LU/257/07/

PLANNING APPLICATION REPORT

DESCRIPTION/ ADDRESS	- Application for the redevelopment of the site to form "56 extra care" frail elderly apartments for the elderly plus ancillary communal facilities, associated carparking facilities and landscaping (Resubmission of LU/124/07) 32, 33, 34 Fitzalan Road and 14, 16 and part garden of 18 Church Street, Littlehampton.
-------------------------	--

STREET SCENE TO FITZALAN ROAD - 1:300

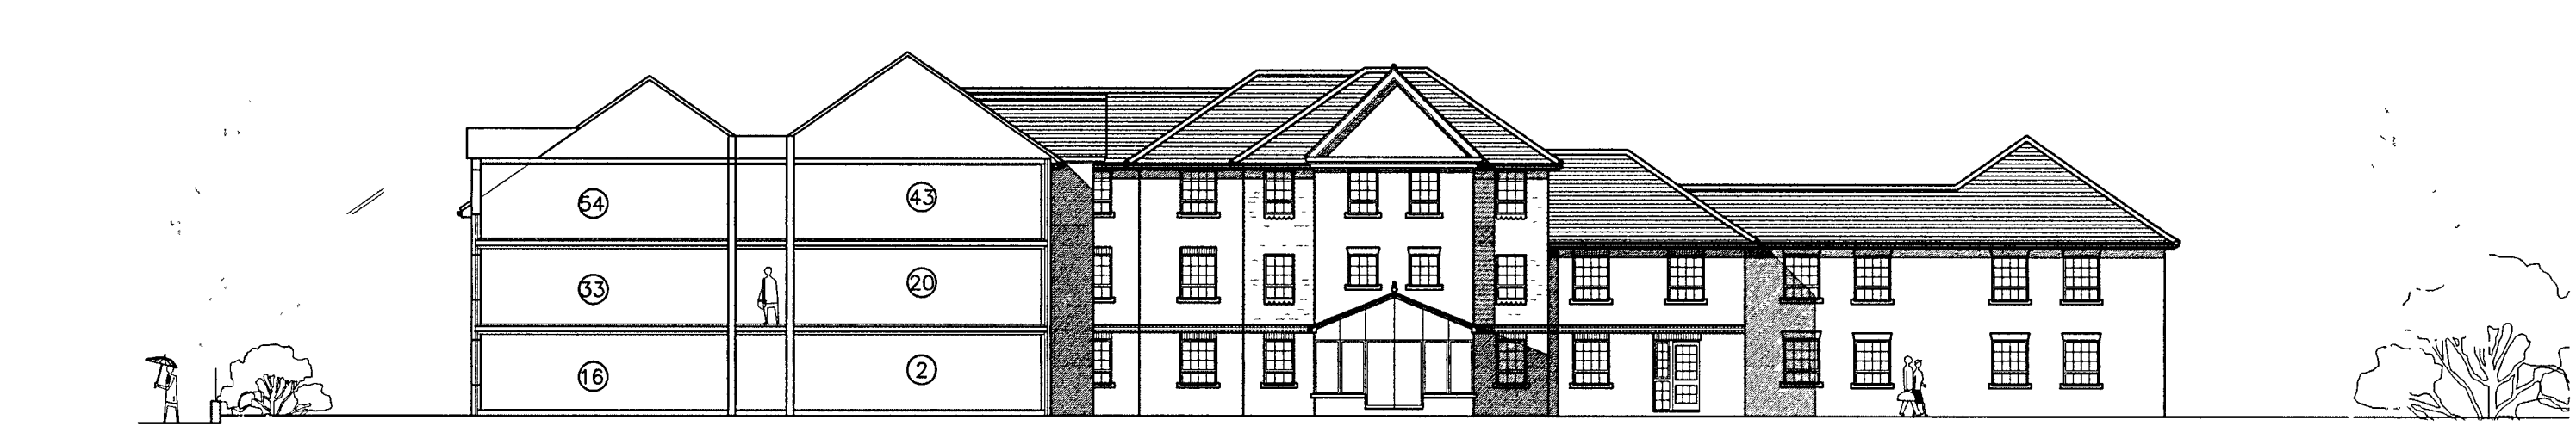
Since refusal of LU/257/07, the applicant has made changes to the scheme by reducing the number of units by 9. On the West Fitzalan Road elevation, this included the deletion of a projecting gable, introduction of a revised three storey element, consisting of a third storey in the form of dormers, and an amended element being two-storey with roof over flanking 31 Fitzalan Road. On the north Church Street elevation, these changes include a revised three storey elements with third floor dormers and a stepped back glazed element. On the east elevation facing the gardens of 18 and 20 Church Street, the three storey elements on the previous scheme have been amended to two and half storey. It is acknowledged that these changes assist in reducing the visual impact but not to a sufficient degree to overcome all the previous reasons for refusal on the Church Street frontage. On this frontage, it is considered that bulk, mass, scale and height adversely affects the character and appearance of the streetscene.

Fitzalan Road has more town like appearance due to the wider variety of building forms and uses. Although characterized by predominantly two-storey development interspersed by gaps, there are larger two storey, two and half and three storey developments. Planning permission has been granted for a community hospital opposite the site but for mainly a two storey recessed development with some three storey. Given the changes that have been made and the context, it is considered that this Fitzalan elevation is acceptable.
